**Consultation Response from Mike Hibbert,
KC Waste Strategy(Refuse & Recycling)**

2023/92966 Land to the rear of, 271, Cliffe Lane, Gomersal, Cleckheaton, BD19 4SB

Demolition of existing dwelling and erection of 87 dwellings including formation of a new access from Cliffe Lane, landscaping, public open space and all associated infrastructure and engineering works

Date Responded: 12/06/2024.

HOUSE TYPE M3, 3 STOREY SPLIT
SEMI, 3BED, 5PERSON = PLOTS
53, 54, 55, 56, 65, 66, 77, 78, 86 & 87

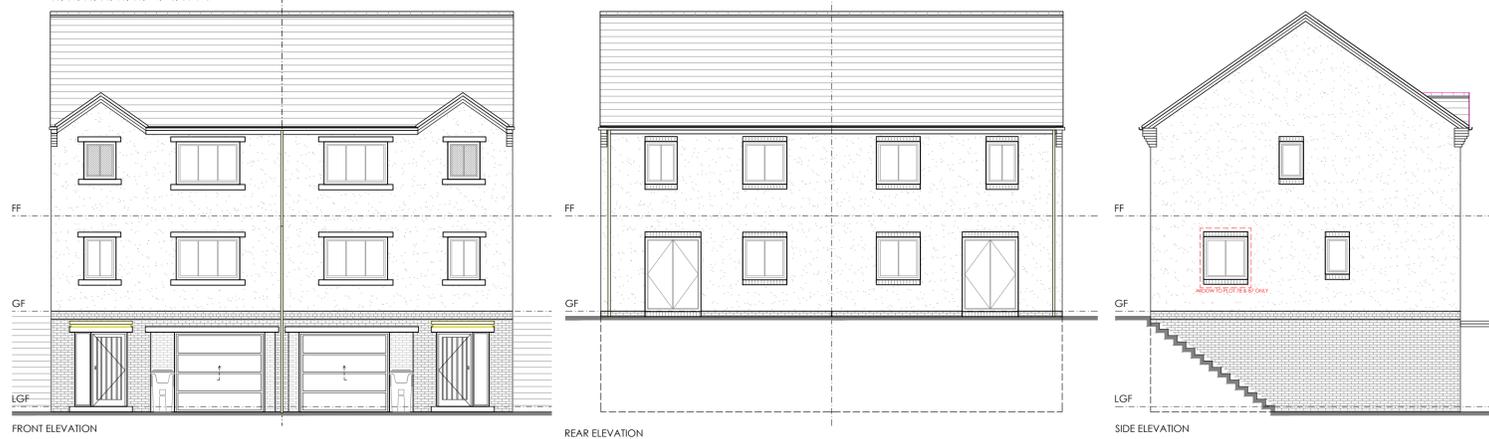
- It is welcomed that that plan indicates that all the properties have space to store 3 x 240ltr wheeled bins to ensure future waste segregation requirements can be met. As the proposed dwellings have private gardens, opportunities to encourage composting should be sought to better meet the Council's 'clean and green' objectives for waste reduction.
- It is noted that Plots 65 to 69, 75 to 78, 80 and 84 to 87 do not have bin storage to the rear of the dwellings due to the topography of the site. On the majority of these plots wheeliebins are shown in a waste storage area front of the property adjacent to the garage door. This location is acceptable if the fire risk assessment does not identify any issues.
